CITY OF ALBUQUERQUE

Re: Carlisle and Menaul
Traffic Impact Study (H16D083F)
Submittal dated May 29, 2025
Via email cvermillion@bhinc.com and ABQ-PLAN

Required infrastructure improvements per the Study include:

D PROPOSED CROSS SECTION
NTS

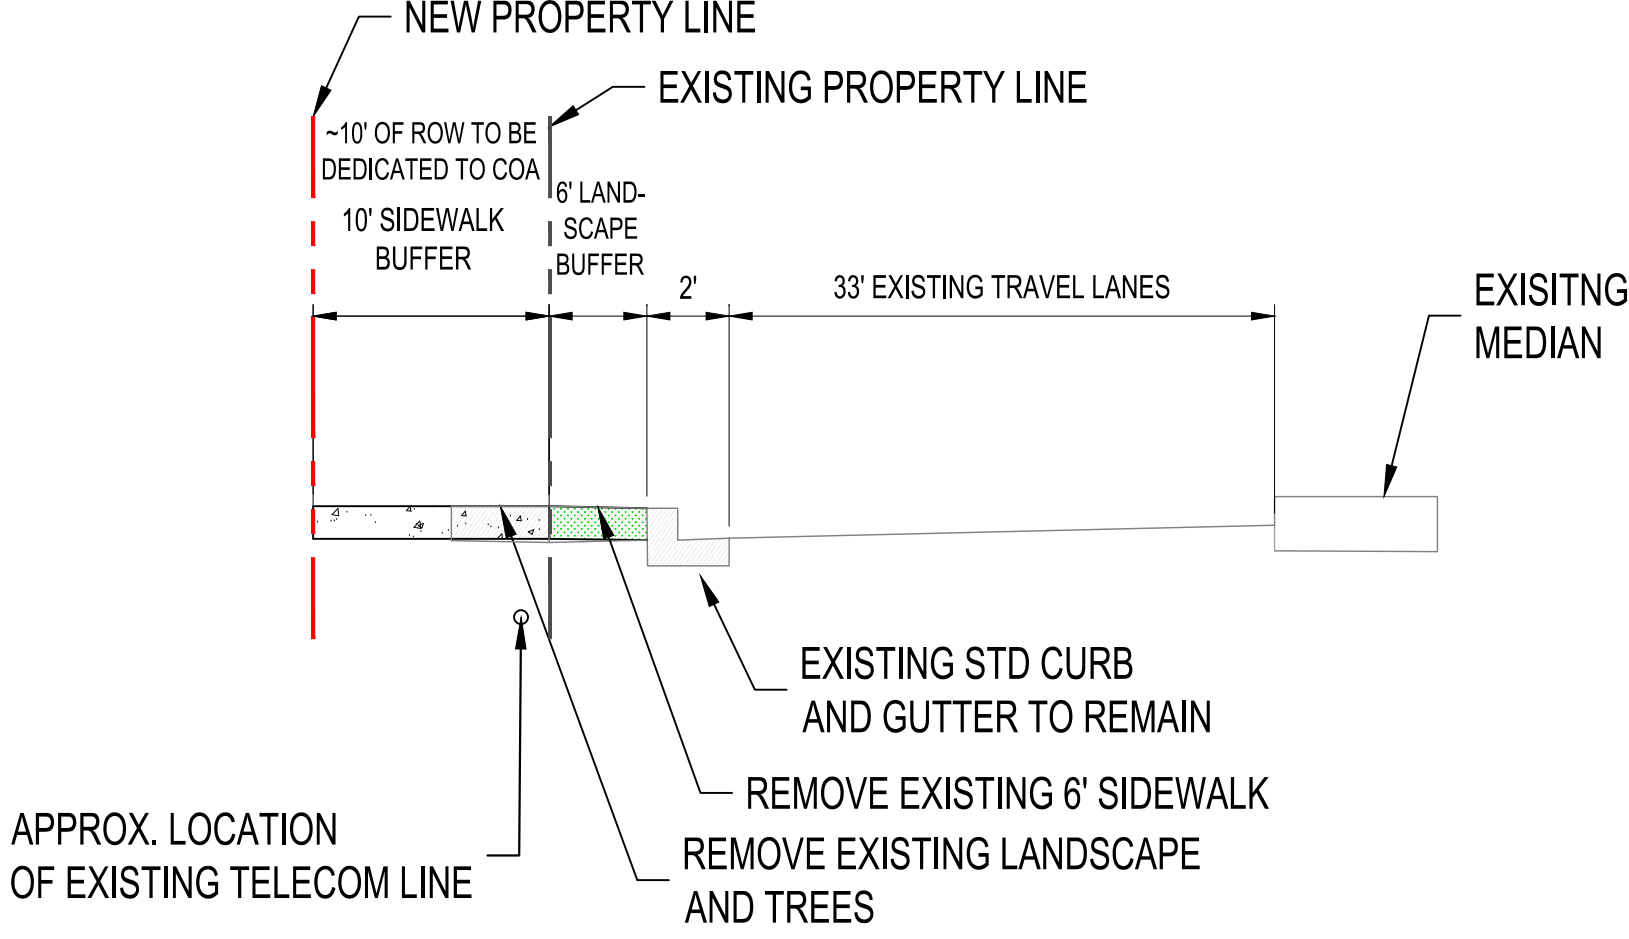
1. Carlisle and Menaul intersection signal timing adjustment to have all movements operate at LOS D or better. Coordinate with Traffic Operations.
2. Access 4 on Carlisle to be redesigned to a single exiting lane with only eastbound right out and south bound right in. Northbound left out to be removed and directional island installed. Also, the median on Carlisle to be modified to eliminate left in movement. New signage to be installed showing no left turns.
3. Access 1 on Menaul to include new one-way sign (R6-1-36) in the median to indicate right turn only.
4. Access 3 on Carlisle install right turn only pavement arrow. Paint median to increase median visibility.
5. All post construction signal optimization recommended in the study..
